## Householder Application for Planning Permission for works or extension to a dwelling

Retention of extensions and alterations built to single family detached house.

Following my inspection of the extensions at 143 Long Lane, Hillingdon, there would appear to be a number of discrepancies between what was approved under 14904/APP/2024/1564 & 14904/APP/2023/3026, compared to what has actually been built. These include:

Project <b>143 Long Lane, Hillingdon, UB10 9JN</b>		
Drawing Title <b>As Built Elevations</b>		
Drawing Title	<b>143 /P/F</b>	Rev.
Rev.	Scale: <b>1/100</b>	Date: <b>Jan 2026</b>

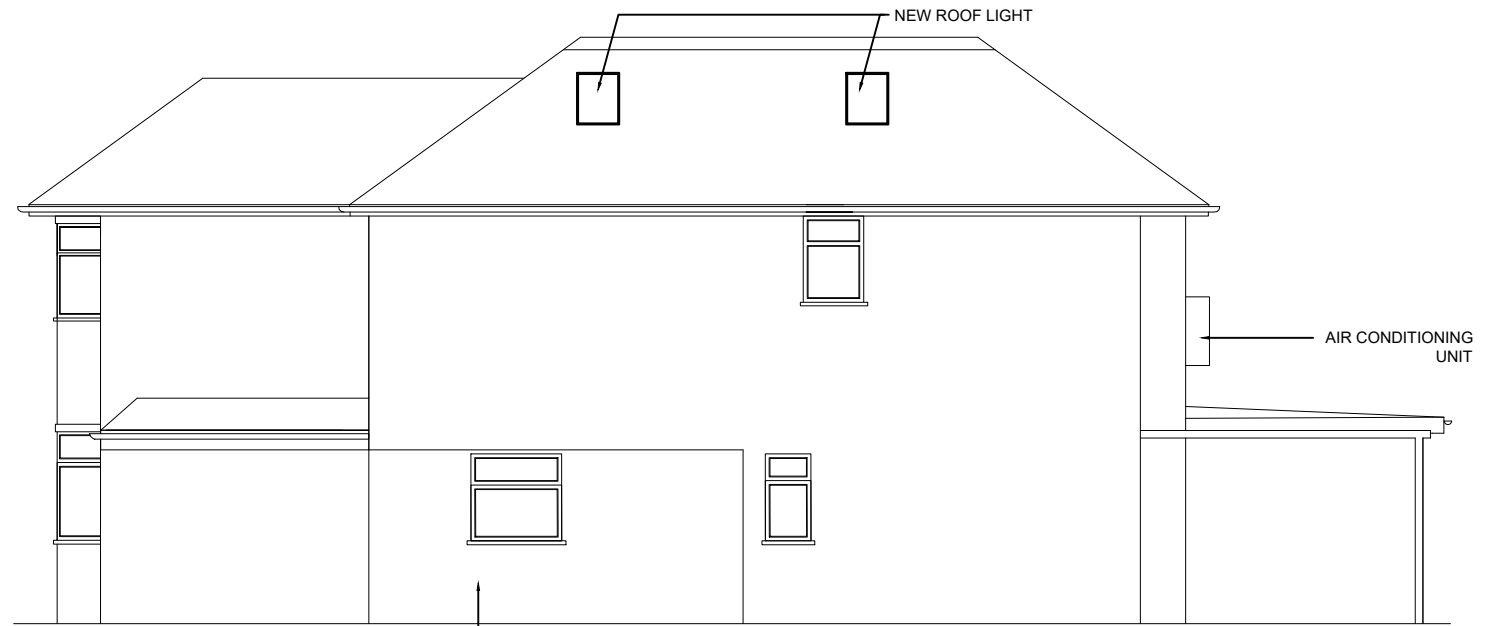
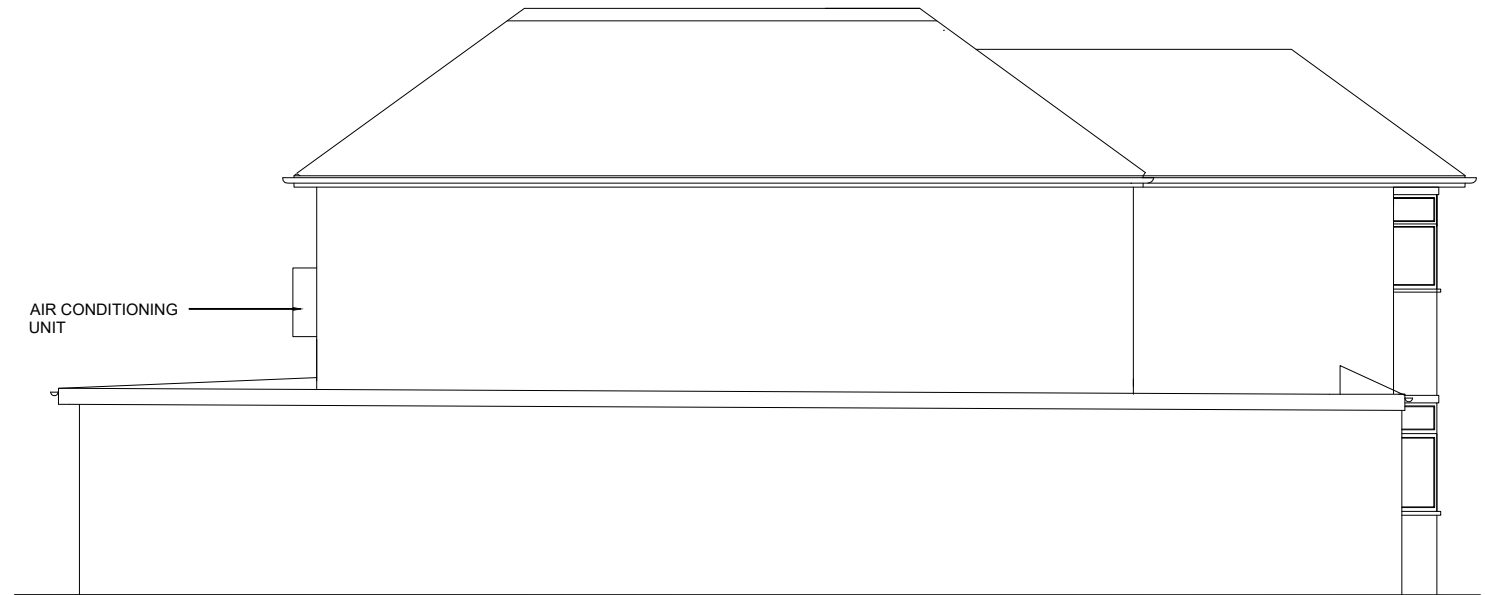
The ridge line of the roof was shown as stepped on the front elevation of 2024/1564, with the left being lower than the right, whereas they are the same

There is a central ridge running from front to back, which was not shown on the approved drawing of 2024/1564

There is a pitched roof (dummy pitch) to the single storey side extension to the left hand side as viewed from the road, whereas the approved drawings show a flat roof.

The first floor side window facing No.145, is openable below 1.8m above finished floor level, which is a breach of condition 4 of 2024/1564

Project	143 Long Lane, Hillingdon, UB10 9JN		
Drawing Title	As Built Floor Plans		
Drawing Title	143 /P/E	Rev.	B
	Scale: 1/100	Date: Jan 2026

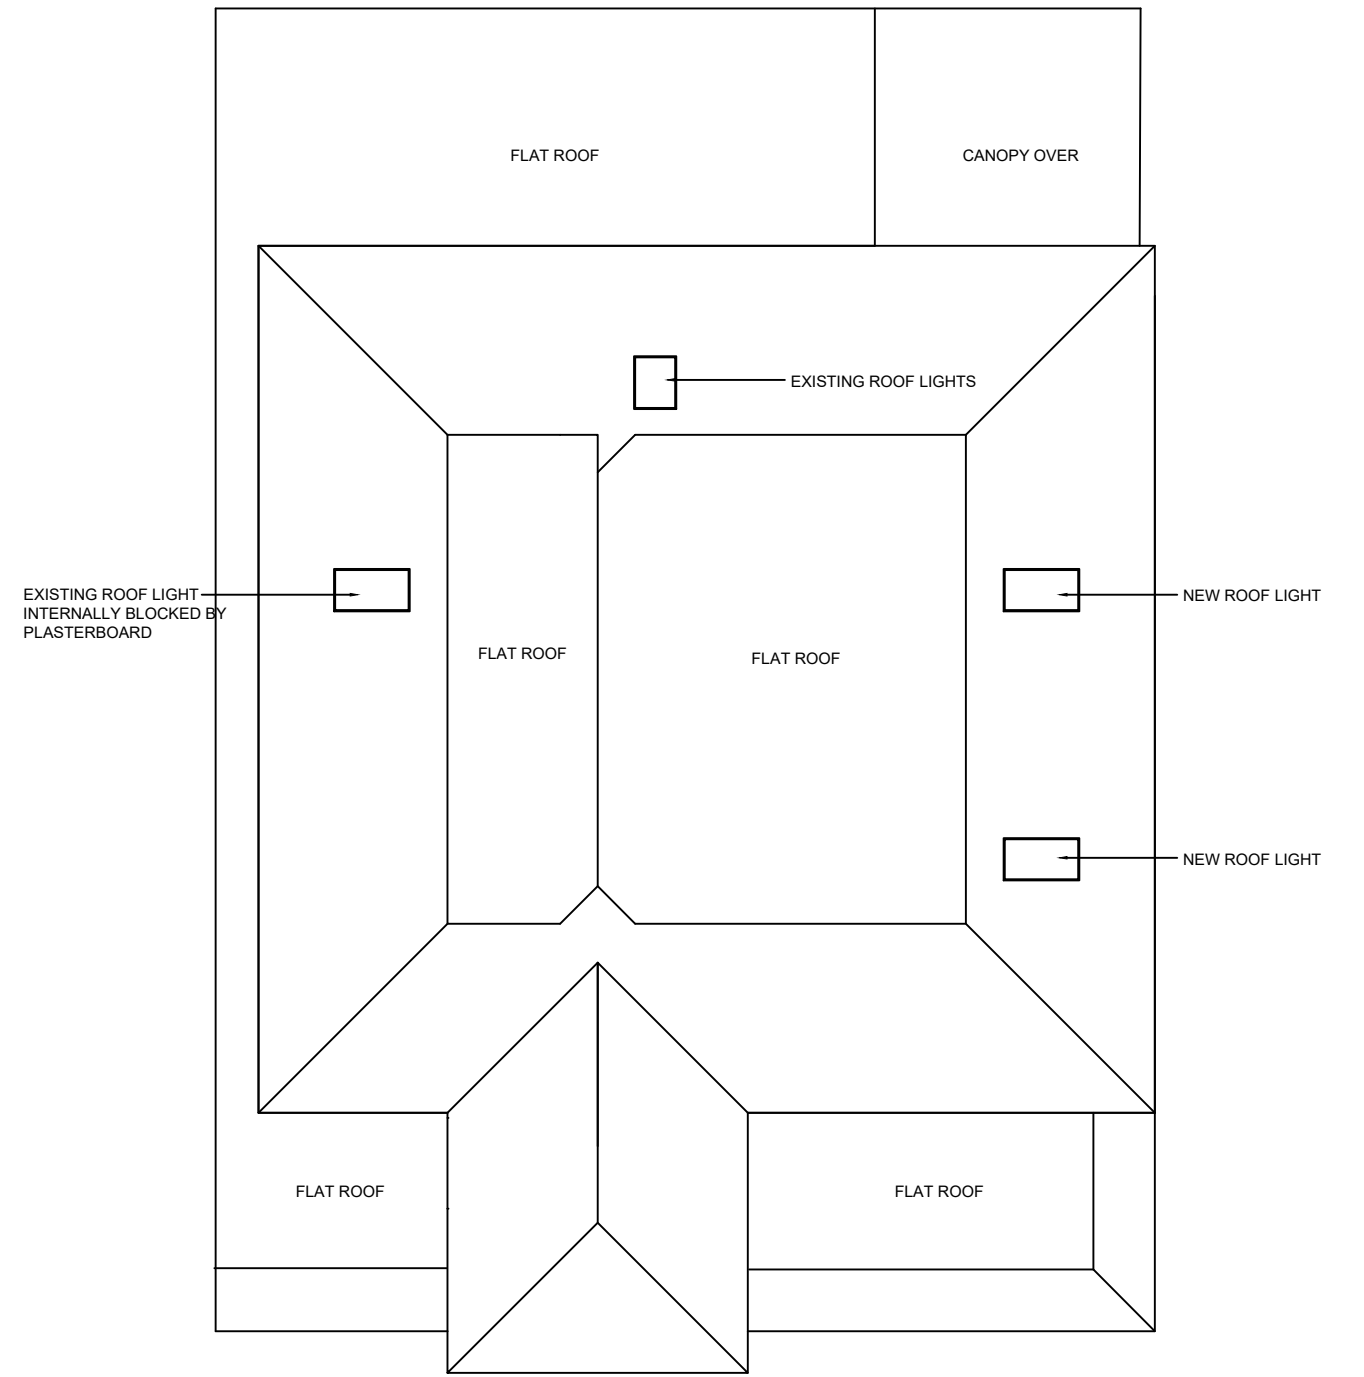
There are two rooflights in the side roofslope facing No.145, which is a breach of condition 5 of 2024/1564

A single storey rear extension (and canopy roof) has been built which is not shown on any approval
